Submission for Job: #6010 SSD 6010 - One Residential Building (Student Accommodation) within Darling Drive Plot

Site: #2824 SICEEP Site, The Haymarket; Darling Drive, Sydney

SSD 6010 - One Residential Building (Student Accommodation) within Darling Drive Plot

29 July 2013

SHADOW DIAGRAMS: PERSPECTIVE, SHOWING THE PEAK, WINTER SOLSTICE

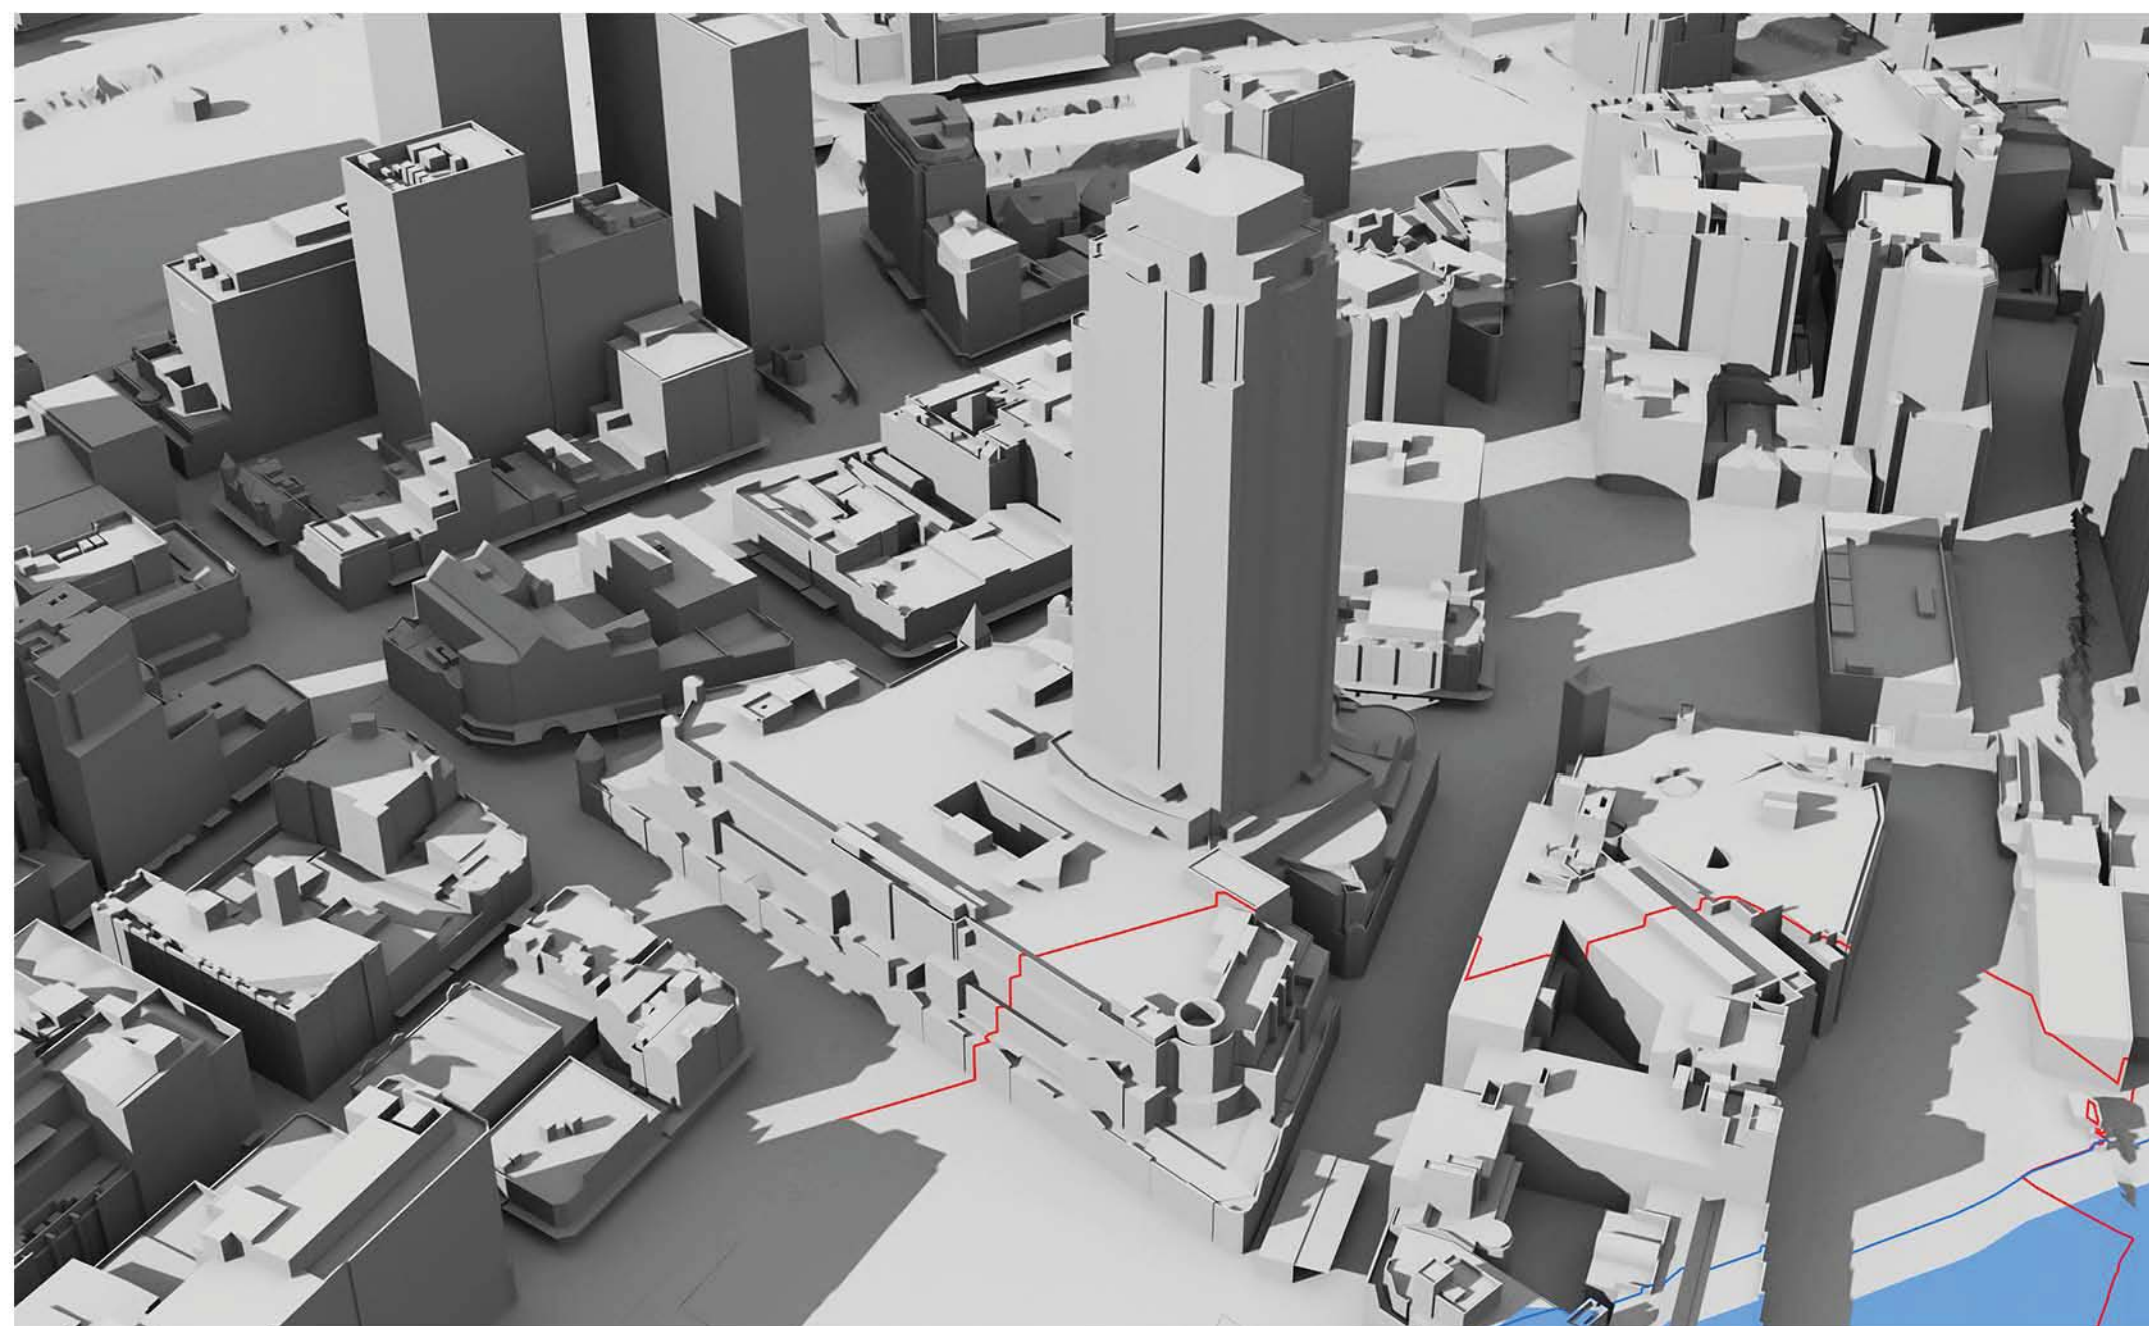
At 9am, 10am and 11am the west façade is totally in shadow due to other parts of The Peak building itself.

At 12pm there is still substantial existing shadowing on the west façade caused by the irregular shape of the west facade.

At 1pm the existing shadowing has been substantially removed, but not totally removed.

It can be concluded that some single aspect apartments on the west façade and some south-west dual aspect corner apartments currently receive less than 2 hours direct sunlight to habitable rooms and 50% of the private open space between 9am and 3pm on 21 June.

At 9am, 10am and 11am the west façade is totally in shadow due to other parts of The Peak building itself.

At 12pm there is still substantial existing shadowing on the west façade caused by the irregular shape of the west facade.

At 1pm the existing shadowing has been substantially, although not entirely, removed. However, overshadowing of lower levels of the west façade by the concept proposal parameter plan shadows for the N,NE and SE plots has already started.

By 2pm the existing shadowing has been totally removed. However, overshadowing of the west façade by the SSDA4 and SSDA5 buildings has appeared and risen further up the west façade than the concept proposal parameter plan shadows for the N,NE and SE plots, which is still present.

At 3pm, the proponent states correctly that 45-45% of the western façade is overshadowed by the SSDA4 and SSDA5 buildings.

It can be concluded that, as a result of combination of the proposed development with existing shadowing of the west façade, some single aspect apartments on the west façade and the south-west dual aspect corner apartments which currently receive less than 2 hours direct sunlight to habitable rooms and 50% of the private open space between 9am and 3pm on 21 June will suffer additional overshadowing. It is beyond our skills to count the number of such apartments. We note that the proponent has made no attempt to do so.
